Jeanie Bourke - RE: Canal Landing New Yard

From: Kevin Gough <gough@archetypepa.com>
To: Jeanie Bourke <JMB@portlandmaine.gov>
Date: 10/1/2014 11:10 AM
Subject: RE: Canal Landing New Yard
CC: Devin Cough <devin@archetypepa.com>, Stephen Bushey <sbushey@fstinc.com>...
Attachments: A0.00 - COVER SHEET.pdf; A1.01 - FIRST FLOOR PLAN.pdf; A1.02 - SECOND FLOOR-MEZZ. PLAN.pdf; A2.01 - BUILDING ELEVATIONS.pdf; A2.02 - BUILDING ELEVATIONS.pdf; A3.12 - STAIR SECTIONS AND DETAILS.pdf; A4.00 - WALL TYPES.pdf; A4.01 - INTERIOR ELEVATIONS.pdf; A4.02 - INTERIOR ELEVATIONS.pdf

Attached are revised drawings with all of the changes you requested, with a couple of exceptions.

**A1.01**

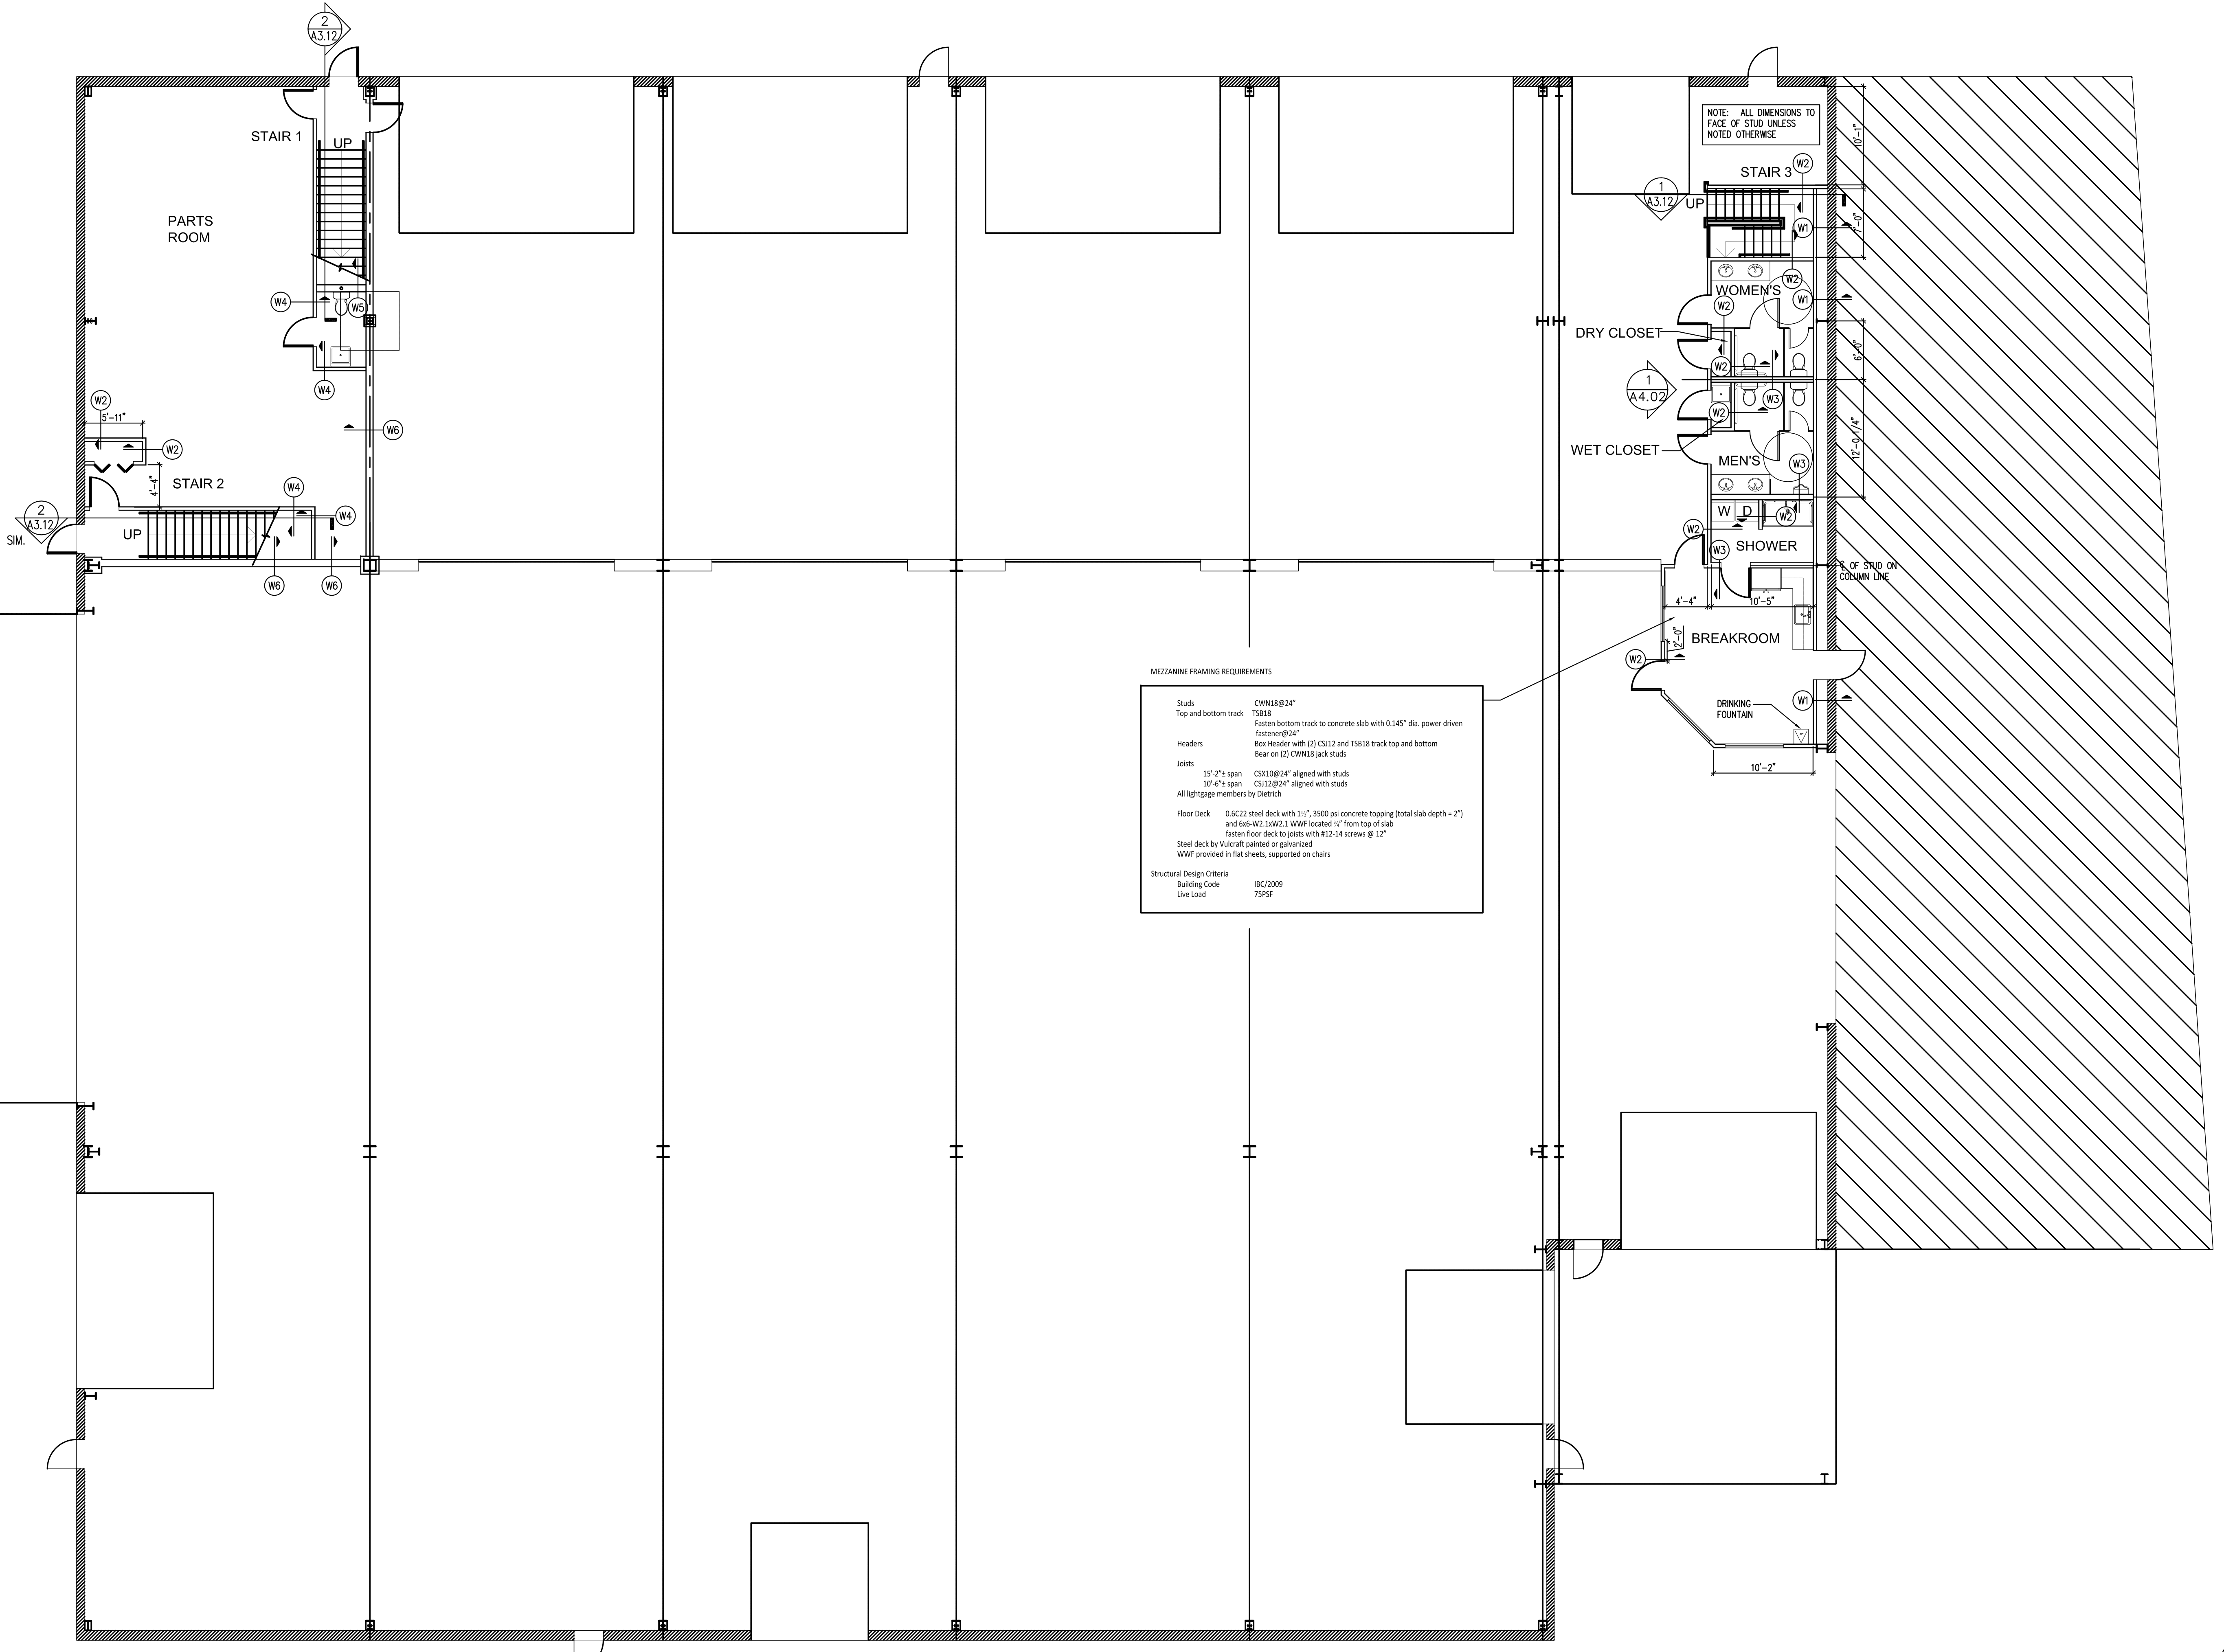
Second, I have a response from David Tetreault regarding your comments on the structural loading at the mezzanine level. His comments follow:

- The live loads of 125 psf and 250 psf noted in IBC Table 1607.1 are for Storage Warehouses (light and heavy storage respectively). I am not certain that this mezzanine area is part of or will be used as a Storage Warehouse. If it is, the Owner should provide a determination as to whether it is to be used as heavy or light storage.

- IBC paragraph 1607.2 allows the live load for occupancies or uses not specified in Table 1607.1 to be determined with a method approved by the building official. IBC paragraph 1607.3 allows the live load to be the maximum expected load.

- The weight of the CB-5000 furnaces to be located in the mezzanine equates to a live load of 50 psf. I increased that uniform load to 75 psf to account for possible heavier future equipment.

- I am available to revise the design for either of the Storage Warehouse loadings noted in IBC Table 1607.1 if the building official does not agree with the method used for determining the 75 psf criteria. If that is the case, please advise as to whether heavy or light storage loading should be used.

His view is that this building is an F-1, and thus the warehouse storage loading does not apply.

**A4.02**

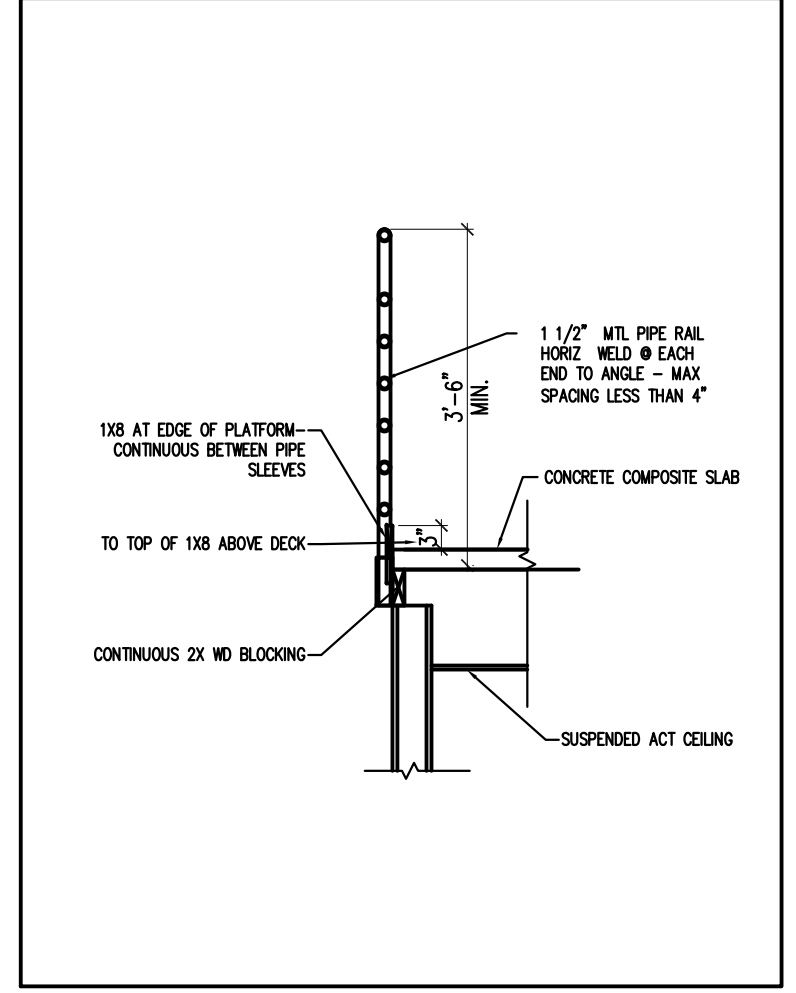
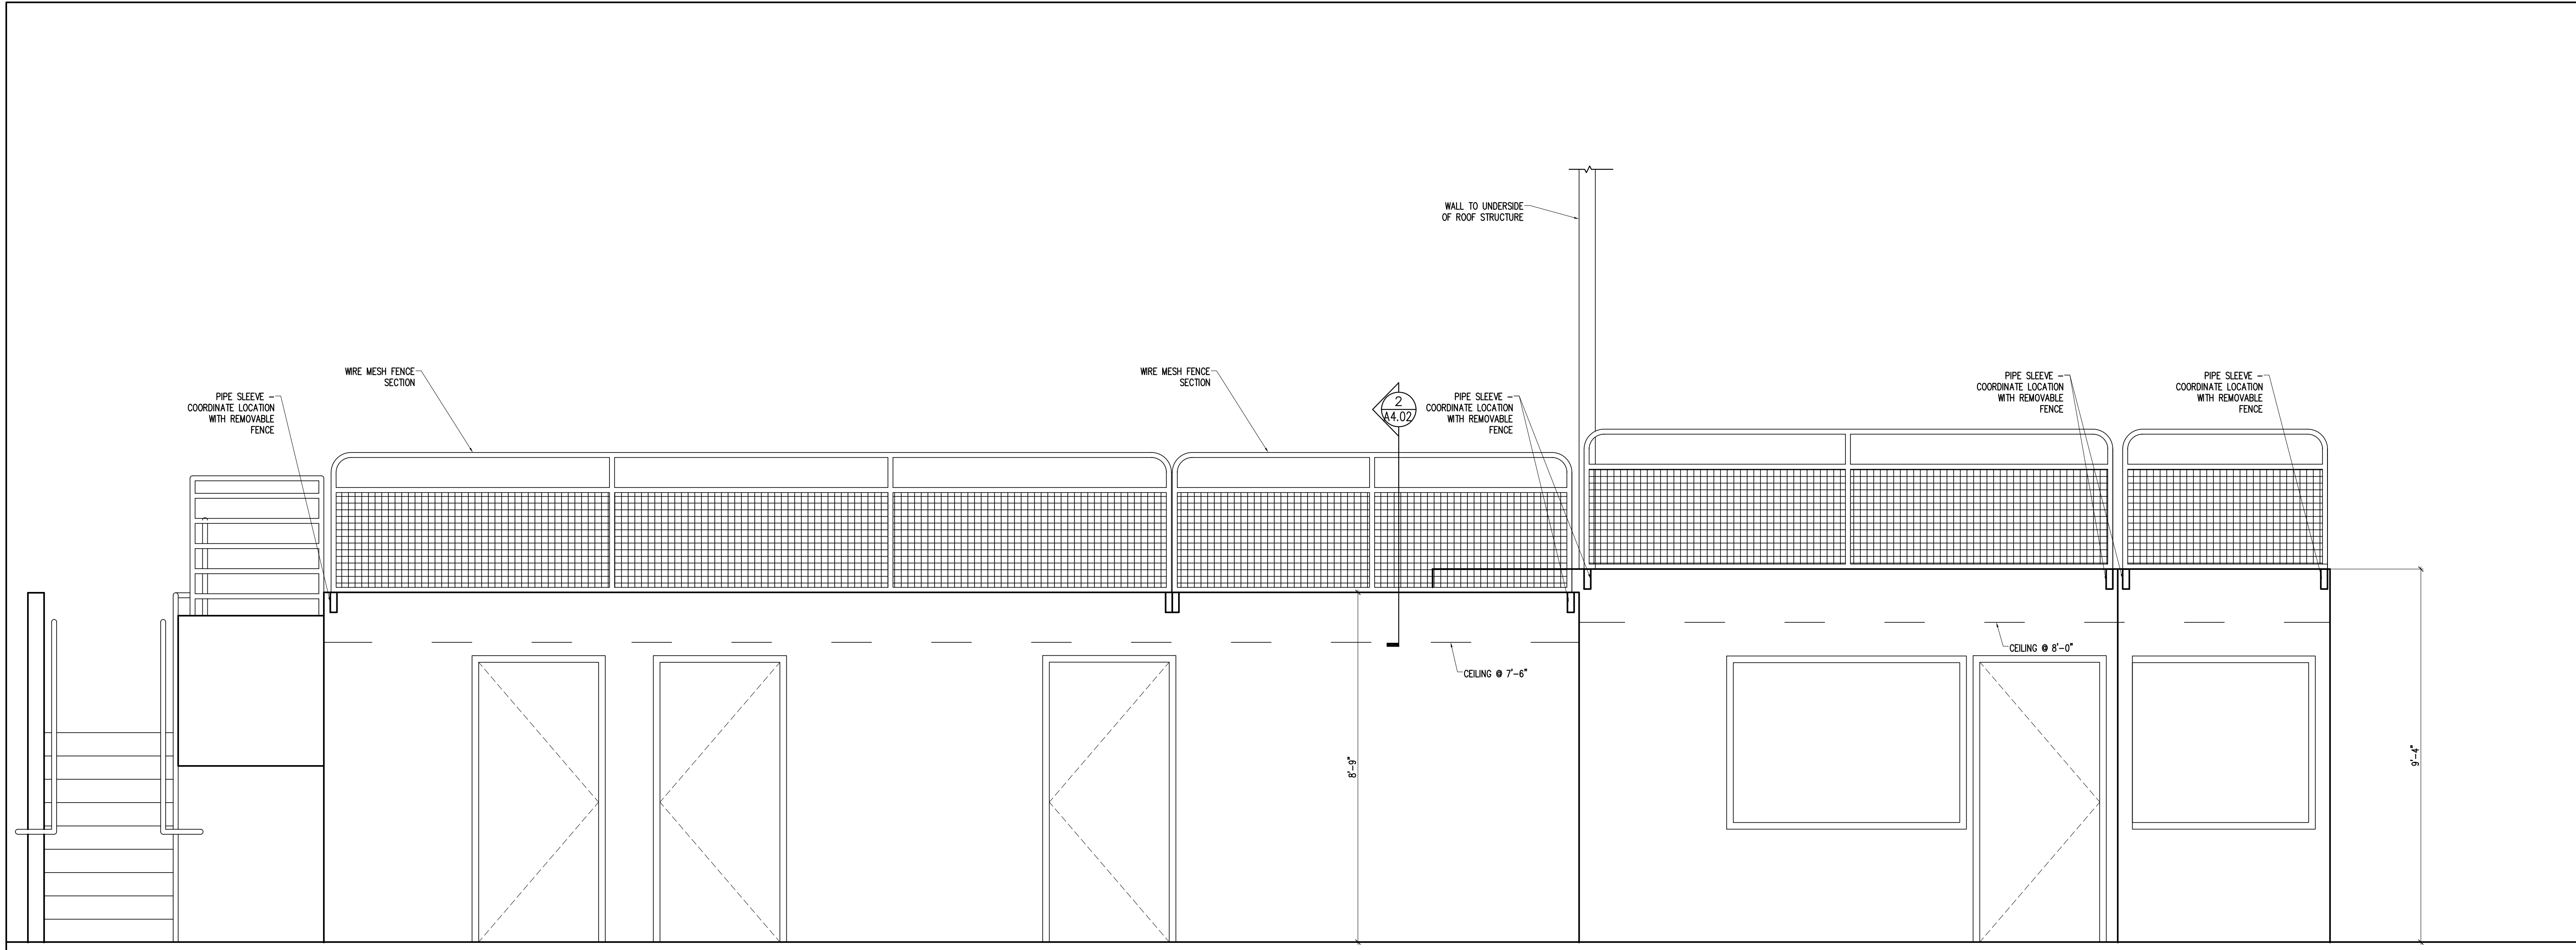
And finally, to address your comment about the occupant loading of the spaces we have labeled "Parts Room" and "Mezzanine" in the Northwest corner, we have noted that these spaces are being designed to be used as storage only at this time. There is no longer an Assembly occupancy portion of the building.
